From: Tim Townsend [REDACTED]
Sent: 05 March 2018 11:05
To: Planning.Responses
Cc: Michael Eastham; Gary Markwell; Juliet Harris [REDACTED]
Subject: LU/278/17/RES - Southern By-Pass, Toddington - Approval of reserved matters - WSCC Highways response dated 5th March 2018

WEST SUSSEX COUNTY COUNCIL
PLANNING SERVICES CONSULTATION

SUBJECT: LU/278/17/RES - Approval of Reserved Matters following Outline Permission LU/47/11 for Construction of the southern section of the Lyminster Bypass, including northern and southern roundabouts, surface water drainage and landscaping. Departure from the Development Plan & affects a Public Right of Way.

LOCATION: North Littlehampton Strategic Development Site, Land West of Toddington Park, Toddington Lane, Littlehampton, BN17 7PP.

Landscape Proposals: SLB3
Northern roundabout

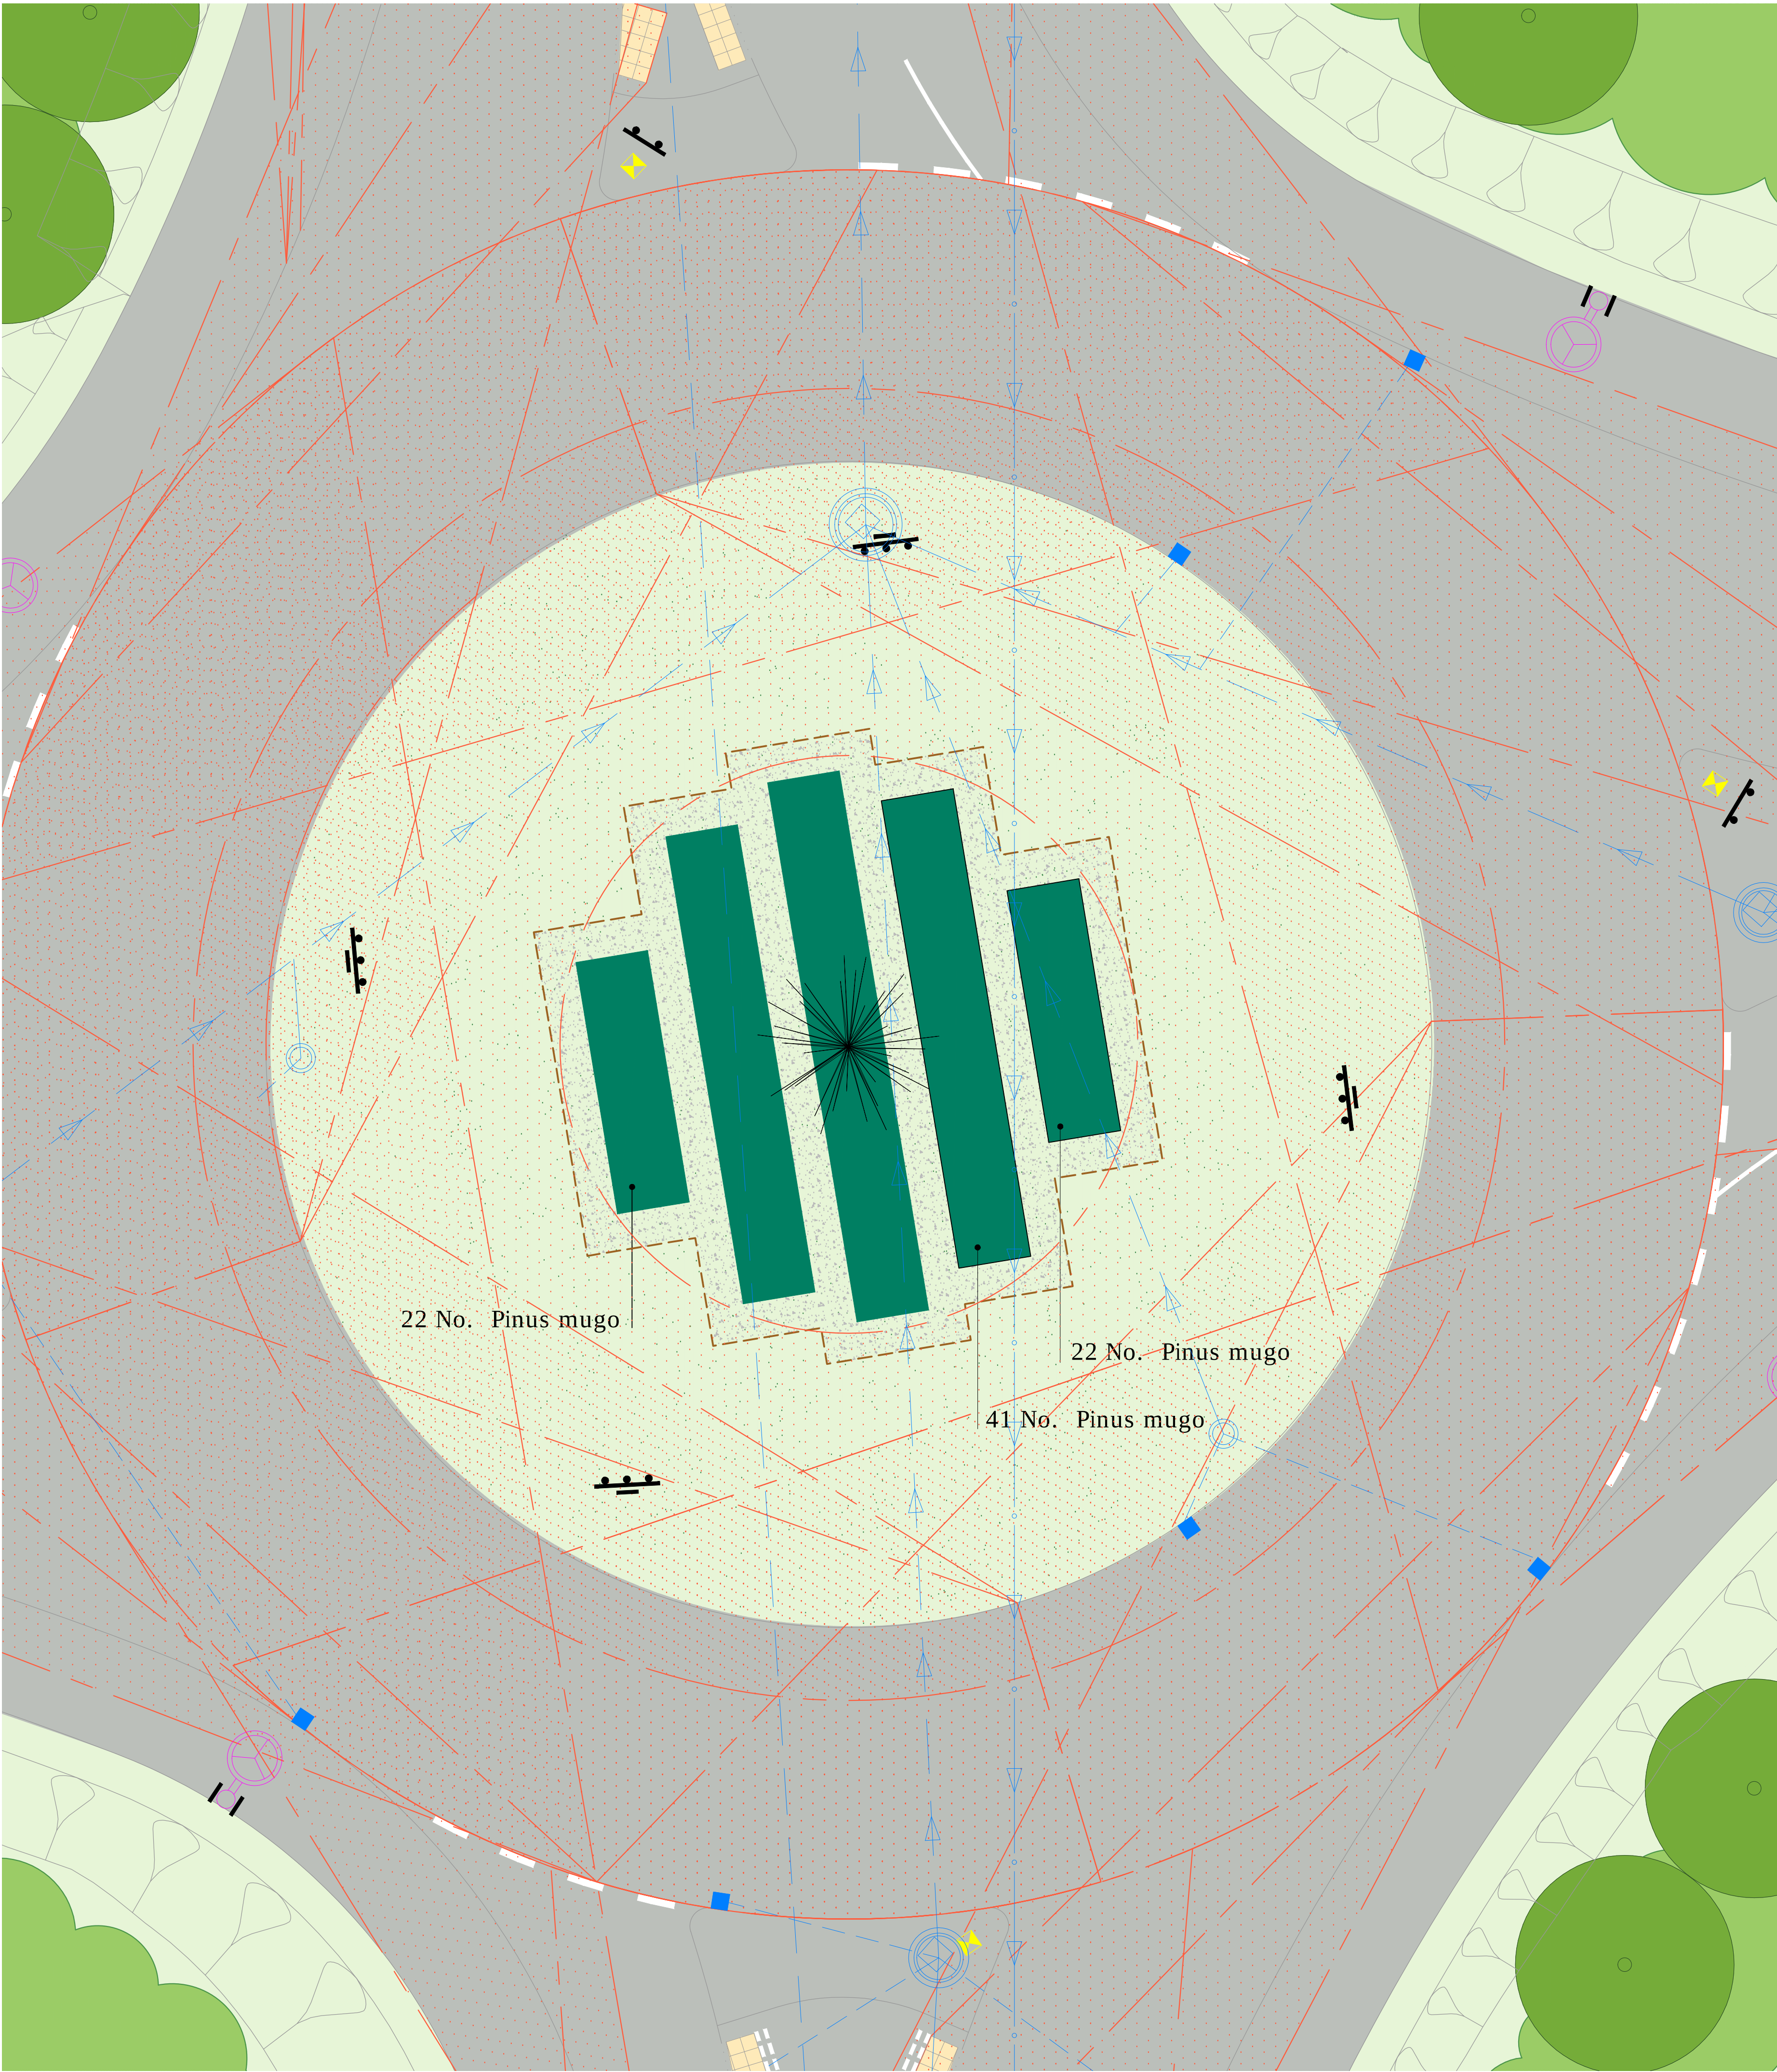
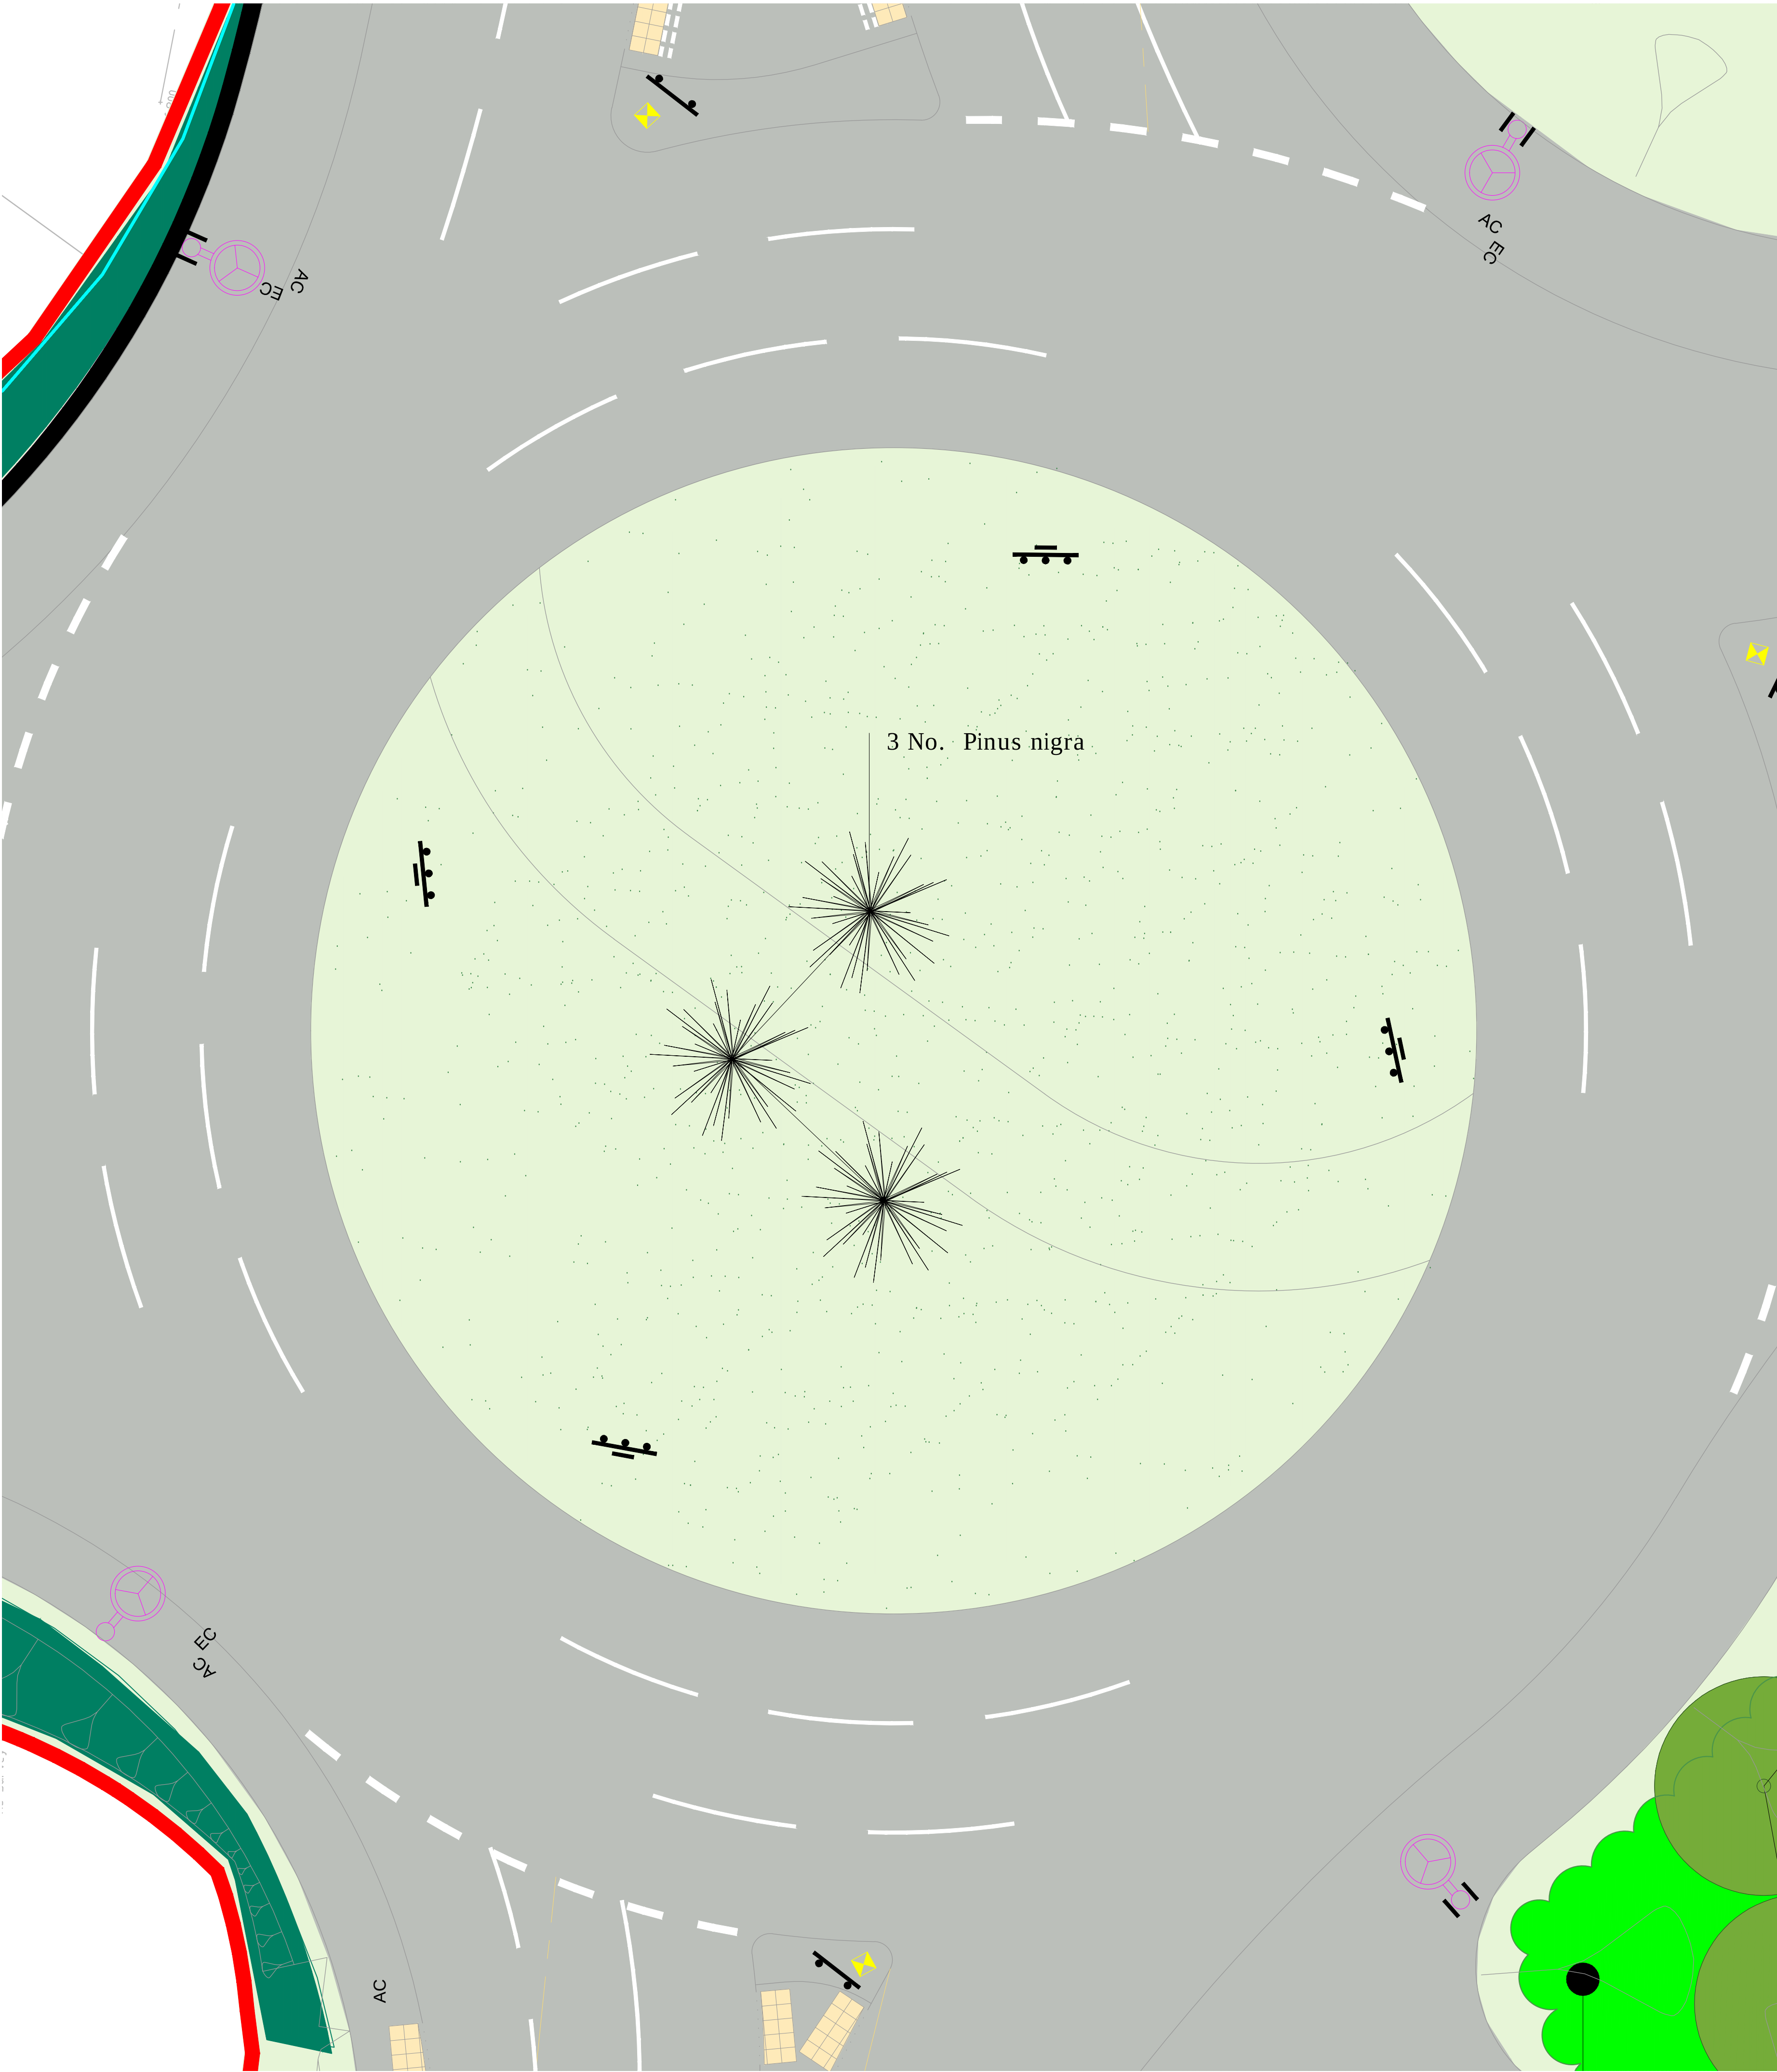
Regarding planting, the CHA previously stated that thorny planting (blackthorn [*Prunus spinosa*], or otherwise) should not be planted adjacent to or close to cycle paths. The applicant has noted and amended this - Thorny shrubs (*Ilex aquifolium*, *Prunus spinosa*, *Rosa canina* and *Crataegus monogyna*) have been removed. *Sambucus nigra* and *Salix caprea* have been added to the mix.

The proposed planting (native tree and shrub planting type 1, 2 and 3) will be individual plants and not linear hedges. This is confirmed by the plant schedule where the spacing between the plants is proposed to be 1 metre centres (hedge planting centres are much denser, normally 0.3m centres). Also, please refer to the 'plant arrangement' heading of the outline specification.

Adequate inter-visibility alongside planting has been provided at cycle path intersections. This will be checked again at the detailed design/S38/278 stage.
